**From:**  
**Sent:** 01 September 2023 16:37  
**To:** DCAdmin  
**Subject:** 2023/44/92254/E. Objection

Newett Homes have applied to alter the size and position of 7 Plots (Plots 14 to 20 which are closest to the ball stop netting) and also the size and position of the ball stop netting. This is because on the original plans there wasn't enough room for the ball stop netting support stanchions as well as room for the claimed PROW which runs adjacent the cricket field stone wall boundary.

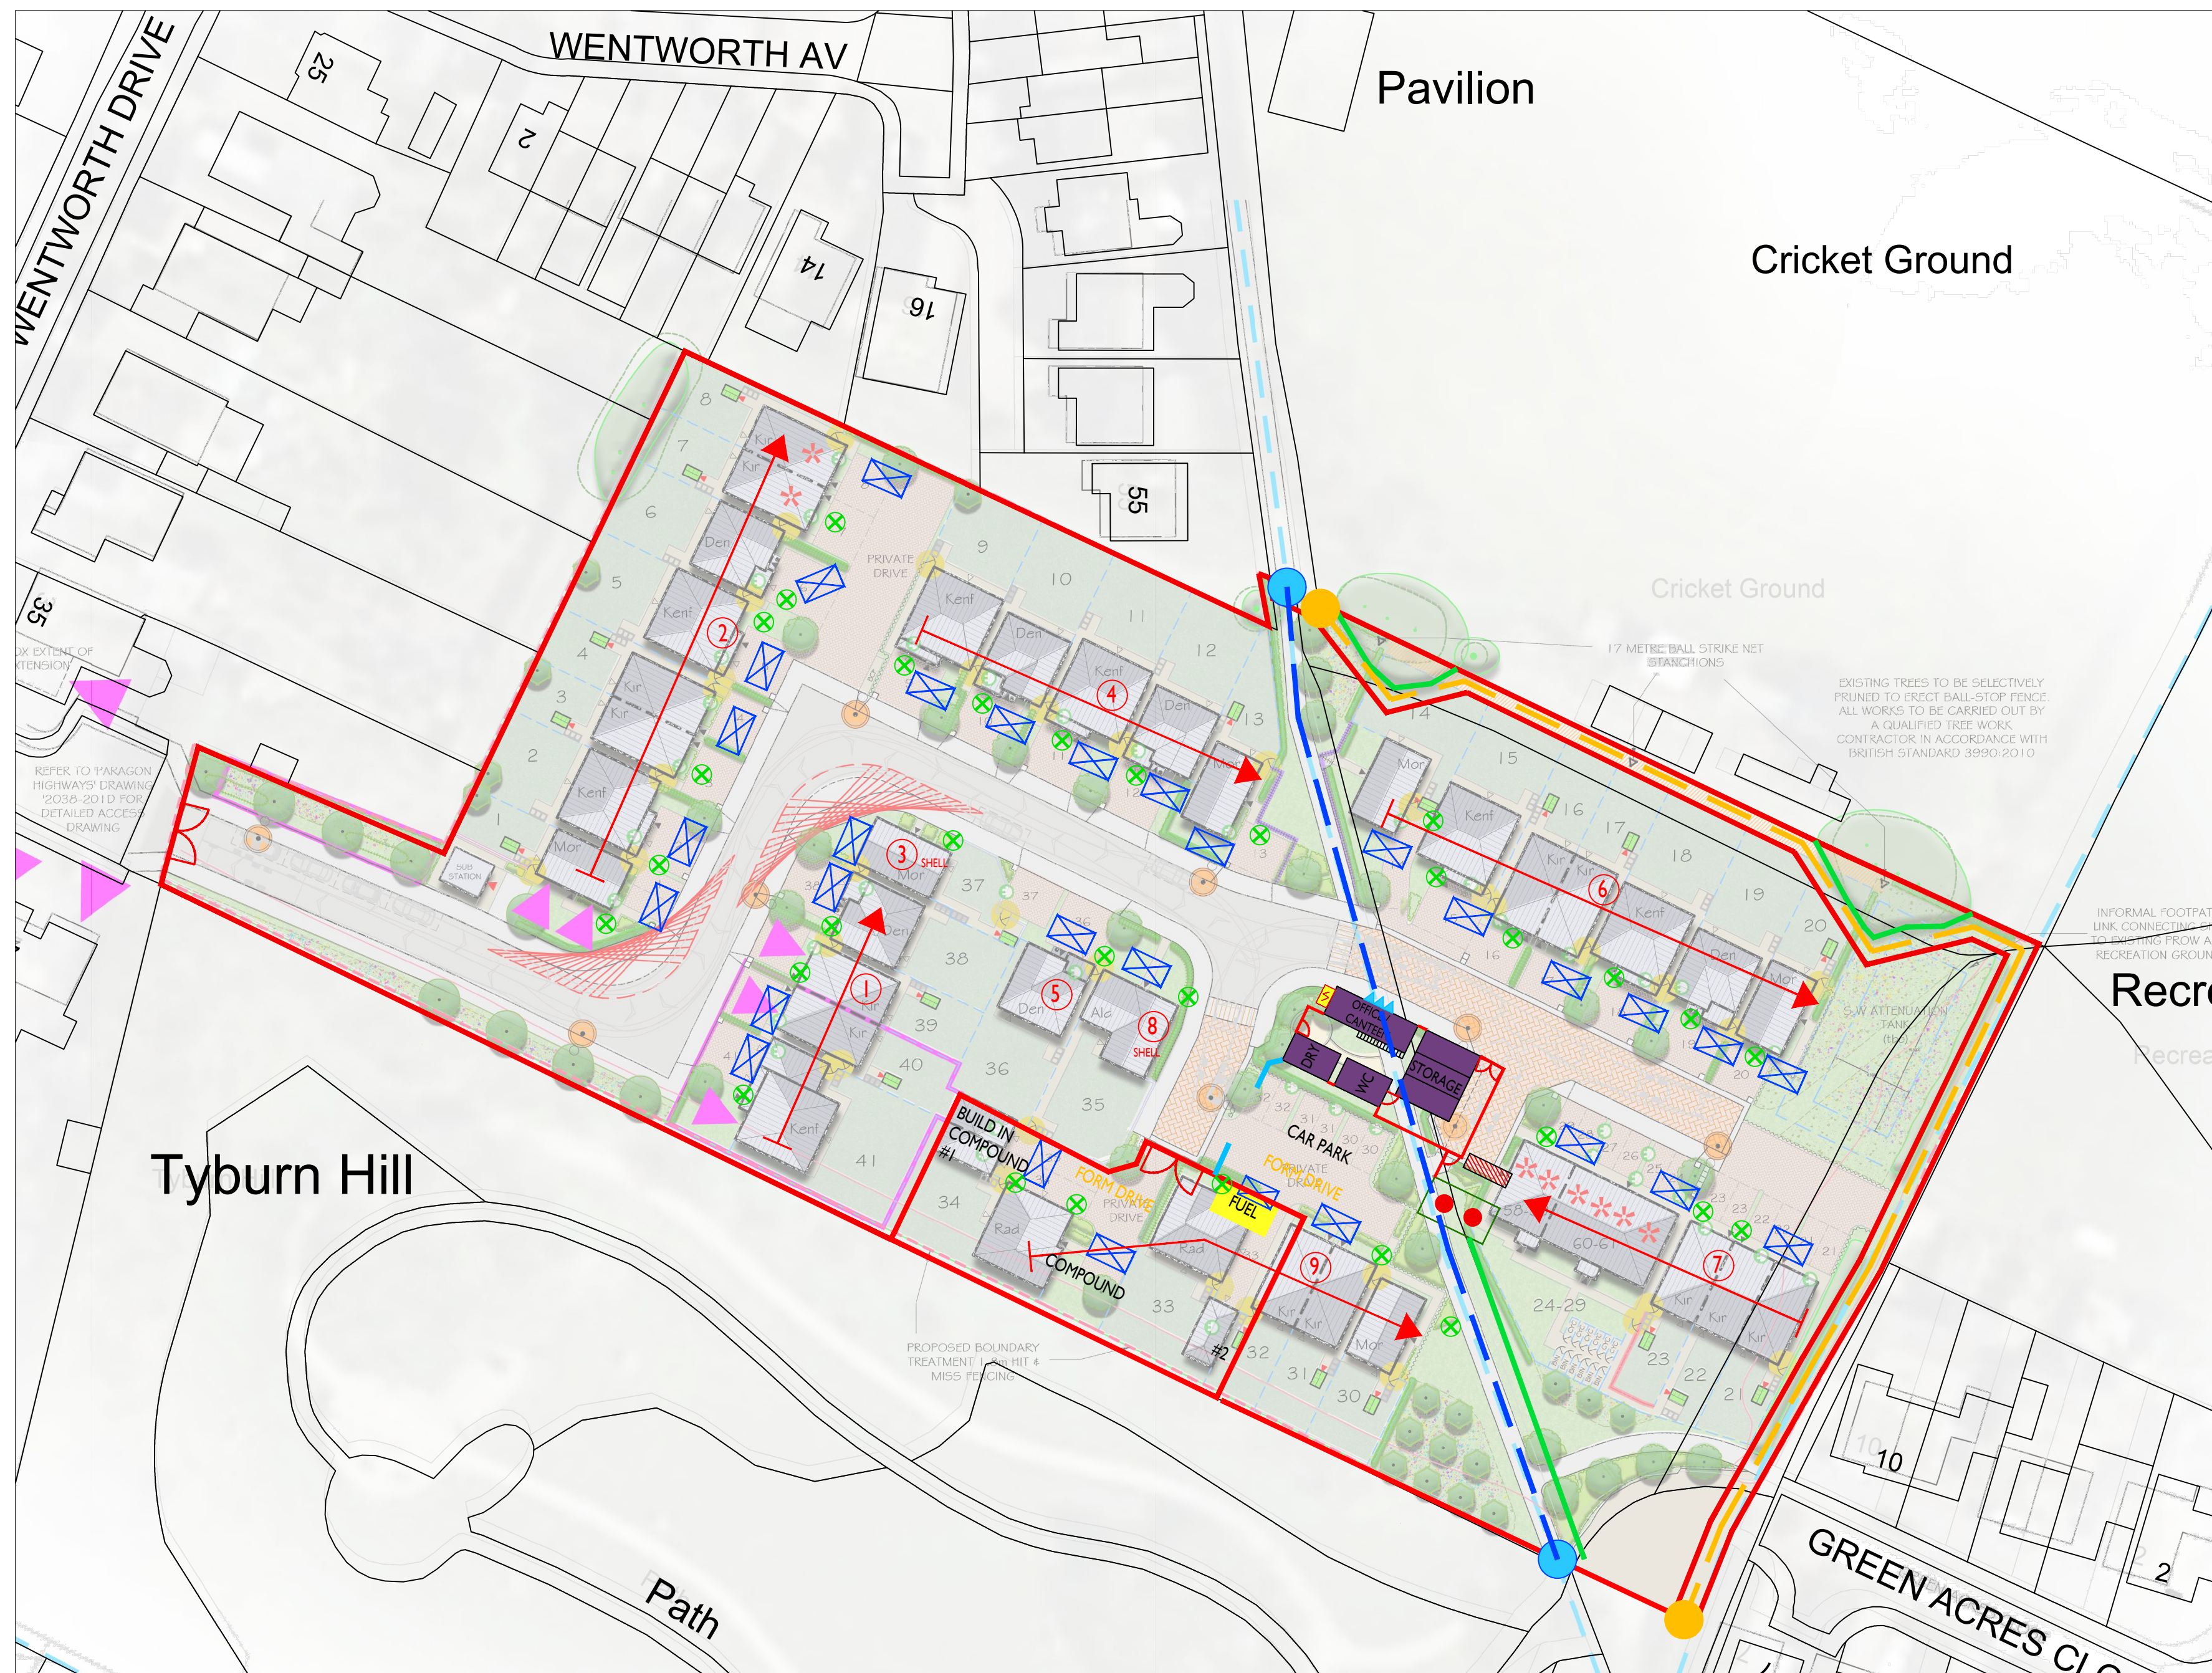
1 - How do Newett Homes propose to protect the Millennium Green’s trees, bushes and wildlife during the development from construction debris, dust and mud, from excess construction noise and artificial lighting too. The Millennium Green is used for the release of recovering hedgehogs from the nearby hedgehog hospital. Newett Homes is aware of this and has been approached by the hedgehog hospital with a request to enter the development site to monitor and/or re-home such hedgehogs who may be along the boundary and within the development site.

Also, there needs to be suitable protection of tree roots on the boundary of the Millennium Green.

2 – How will Newett Homes ensure access to the Emley Millennium Green and other public areas are not impeded during the development.

5 – Parking of construction workers' vehicles will be an issue, what are the plans?

6 – Reassurance that the access from Green Acres Close will not be used by construction workers or deliveries.
